**Appeal for the Redevelopment of part of golf course to provide new leisure resort (sui generis) incorporating waterpark, family entertainment centre, hotel, conferencing facilities and restaurants with associated access, parking and landscaping at Land to the east of M40 and south of A4095 Chesterton Bicester Oxon**

**PINS reference: APP/C3105/W/20/3259189**

**LLFA response to Curtins Letter dated 11<sup>th</sup> December 2020**

**Proposed Great Wolf Lodge, Chesterton, Bicester – Proposed Attenuation Tank**

Figure 3-6: UAV Groundwater Survey

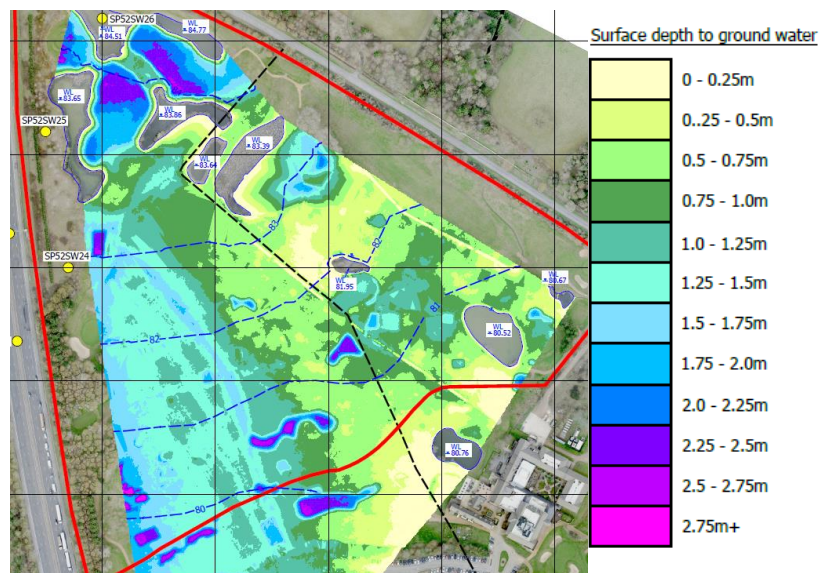
As you have stated groundwater is between 0-0.5m below ground level in places, especially where the tank is proposed. That is why the existing features are shallow to manage surface water above the groundwater which is in line with best practice. However, the proposed solution is proposing to manage surface water significantly lower with the proposed tank invert level 2.5m below the proposed ground level.

As you have stated this area is at high risk of groundwater flooding. The proposed scheme to manage groundwater is to reinstate the land drains on the proposed site at a lower level however, there is no evidence to demonstrate this will have a positive effect as this is controlled by the levels downstream which are not being altered.

Figure 4-3: Surface Water Discharge Route

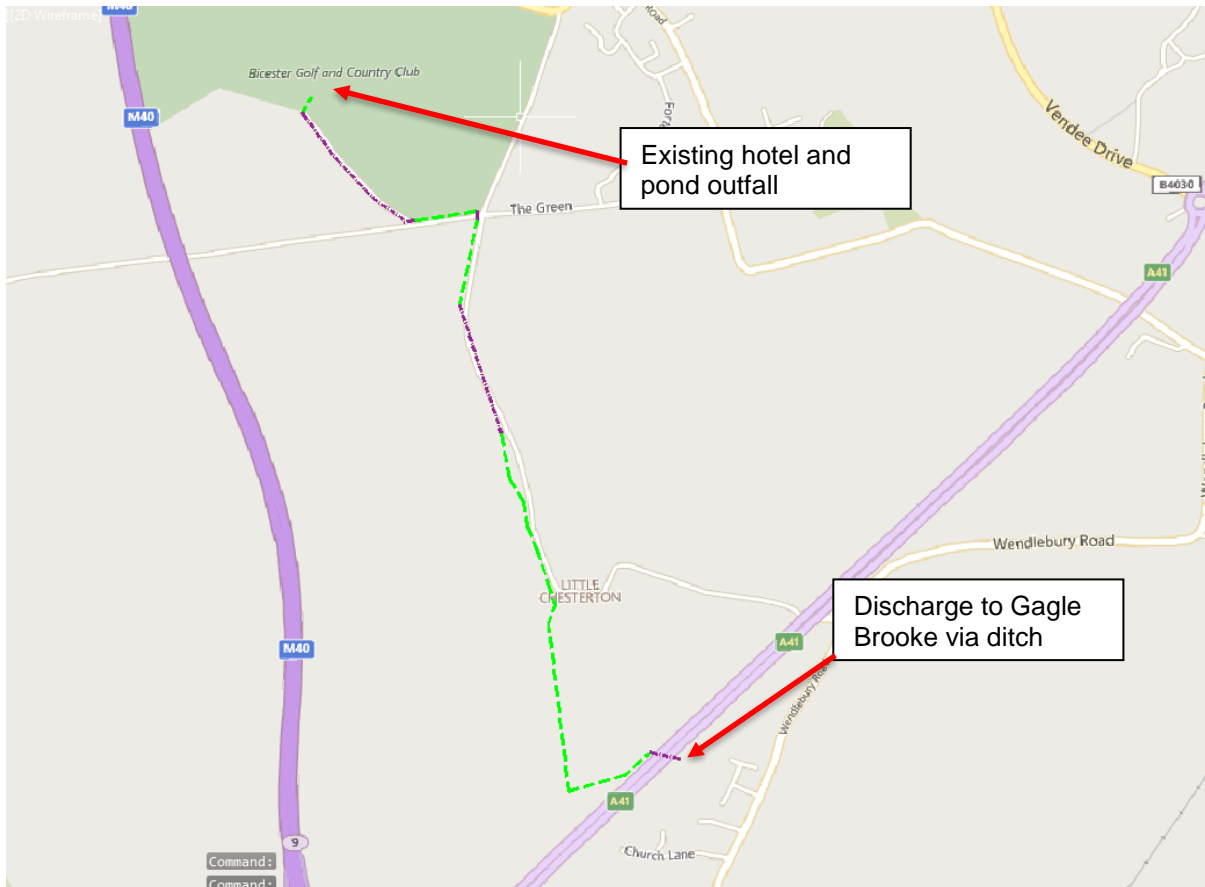
The outfall is set by site topography, but the existing outfall in the calculations is shown to be 78.262m which we are now aware is assumed and the ditch level adjacent to this manhole is shown to be 79.778m.

The existing drainage outfalls via shallow ditches/swales to a manhole on the southern boundary of the proposed site. The level in existing MH EXSW1 is not known but the ditch level adjacent to this manhole is shown to be 79.778m. The proposed level is 1.5m lower which suggests a significant change in level to manage the drainage is proposed.

The FRA and Drainage Strategy are misleading as they have not mentioned at all that this outfall level is assumed. Looking at the existing topography downstream, we cannot see evidence that demonstrates how the drainage will work at the proposed level and this needs to be confirmed.
